## PLANNING CONSULTATION RESPONSE

<b>Application No</b>	<u>2026/0074</u>
<b>Proposal</b>	Formation of hardstanding and boundary wall to provide 1 no. enclosed off street parking space
<b>Address</b>	13 Fitzwilliam Street, Hoyland Common, Barnsley, S74 0NJ
<b>Date of Consultation Reply</b>	07/05/26
<b>Consultee</b>	Highways Development Control

PROPOSED SITE PLAN 1:500

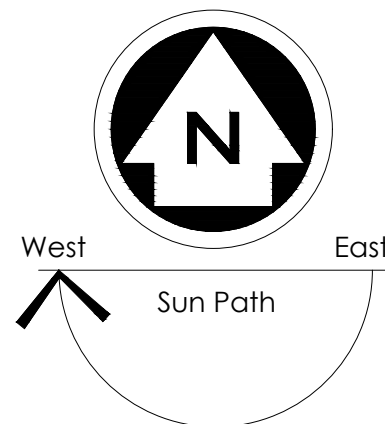
Whilst it is acknowledged that the proposal seeks to provide off-street parking and that an approximate 5m carriageway width would remain within Club Street, which in isolation may be sufficient to accommodate two-way vehicle movement, concern remains regarding the likely operational impact of parking behaviour in this location.

The surrounding area is characterised predominantly by terraced properties with no access to off-street parking, and accordingly residents are reliant on the limited on-street parking available. The introduction of a formal private parking space, together with the associated 2m perimeter footway, would alter the existing layout and may encourage informal or opportunistic parking adjacent to the proposed footway edge. Should this occur, the effective carriageway width would be reduced to the detriment of vehicular movement, potentially leading to difficulties for opposing vehicles passing, restricted manoeuvrability, and obstruction to vehicles accessing the existing residential properties and the Working Men's Club car park served from Club Street. It is also noted that cellar access for the Working Mens Club is via Club Street, and whilst I have no details as to the delivery operation for the premises, it is fair to assume that brewery deliveries are undertaken from Club Street adjacent to the access.

In addition, pedestrian intervisibility splays of 2m x 2m cannot be achieved on exit from the proposed parking space due to the position of the adjoining property. This gives rise to highway safety concerns directly associated with the proposal.

Taking all matters into consideration, the proposal is not considered acceptable from a highways perspective. In particular, the development would give rise to highway safety concerns arising from inadequate pedestrian intervisibility, together with the likely detrimental impact on the operation of Club Street and the pressure placed on existing on-street parking provision for surrounding residents. Highways Development Control therefore raise objection to the application.
